Rezoning Transportation Analysis

Petition Number: #2022-161

Revision Log:

Date	Description
02-23-23	First Review (PDM)
04-20-23	Second Review (PDM)
05-24-23	Third Review (DR)

SHEET NO.	SHEET NAME
1 of 3	CONCEPTUAL SITE PLAN
2 of 3	TECHNICAL DATA
3 of 3	MASTER PLAN

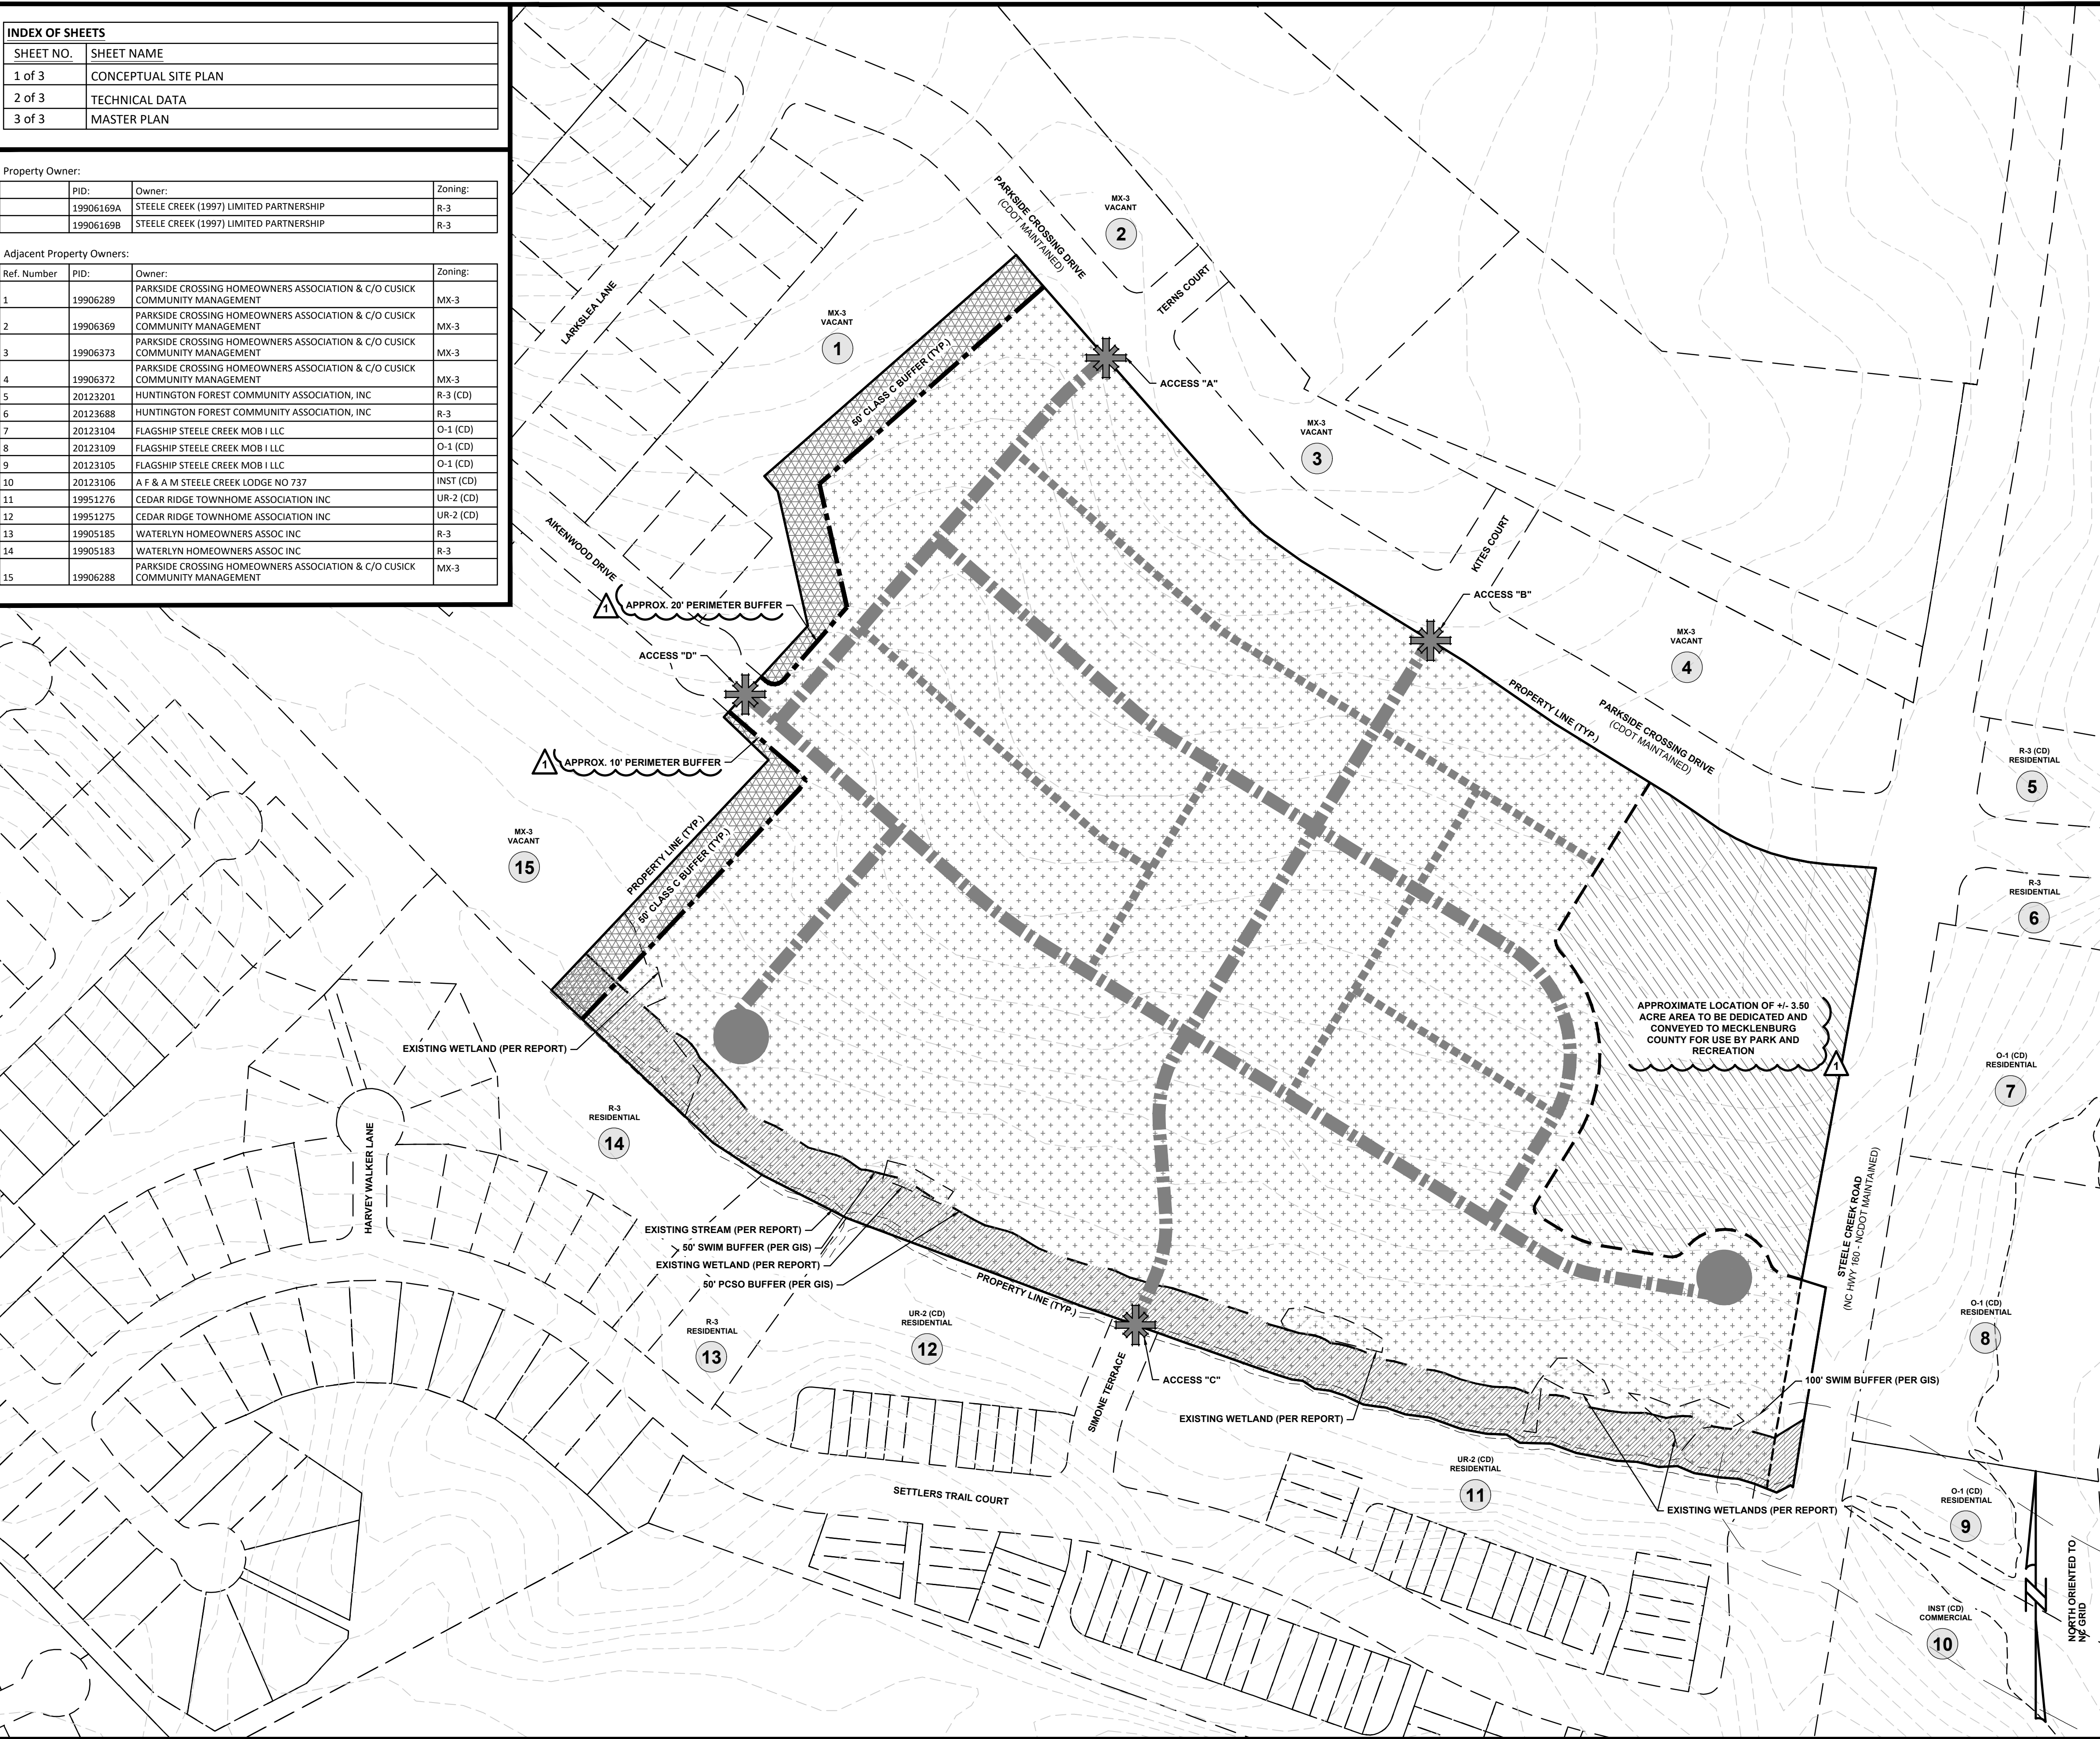
- a. ~~**Steele Creek Road:** Location of the future curb and gutter to be installed at 33 feet from roadway centerline to accommodate the Charlotte Streets Map roadway typical section of four plus lane avenue with shared use path. The future curb and gutter should be shown on the plan and dimensioned from the centerline.~~

- b. ~~**Parkside Crossing:** Location of the future curb and gutter to be installed at 17.5 feet from roadway centerline to accommodate the Charlotte Streets Map roadway typical section of collector street per CLDSM U-07. The future curb and gutter should be shown on the plan and dimensioned from the centerline.~~

~~Label and dimension the curb and gutter from the centerline for each road on the site plan.~~

~~3. Revise site plan and conditional note(s) to commit to dedicate all necessary ROW and easements along Steele Creek Road for the NCDOT U-5766B project.~~

~~4. Revise site plan and conditional note(s) to show the previously approved sidewalk and the curb and gutter along Parkside Crossing.~~

~~5. Revise site plan and conditional note(s) to commit to construct bicycle facilities by installing a 12' multi-use path to meet the Council-adopted Charlotte BIKES Policy. Multi-use paths maintained by the City shall meet ADA/PROWAG requirements.~~

~~6. CDOT REQUEST: Revise site plan and conditional notes to commit to providing a 12-ft multi-use path connection from the proposed cul-de-sac to the proposed MUP along Steele Creek~~

7. ~~Revise site plan and conditional notes to commit to removing the existing turnaround on Aikenwood Drive at the proposed Access D Street connection.~~

~~Update to Comment 4.20.2023: Show proposed road extension tying into Access A.~~

~~**Update to Comment 4.20.2023:** A trip generation comparison was provided by the petitioner. The expected trip generation is comparable to what was previously approved, and an updated traffic study will not be required by CDOT.~~

~~**Update to Comment 4.20.2023:** Steele Creek Road is a major thoroughfare and requires a minimum of 50ft of ROW dedication.~~
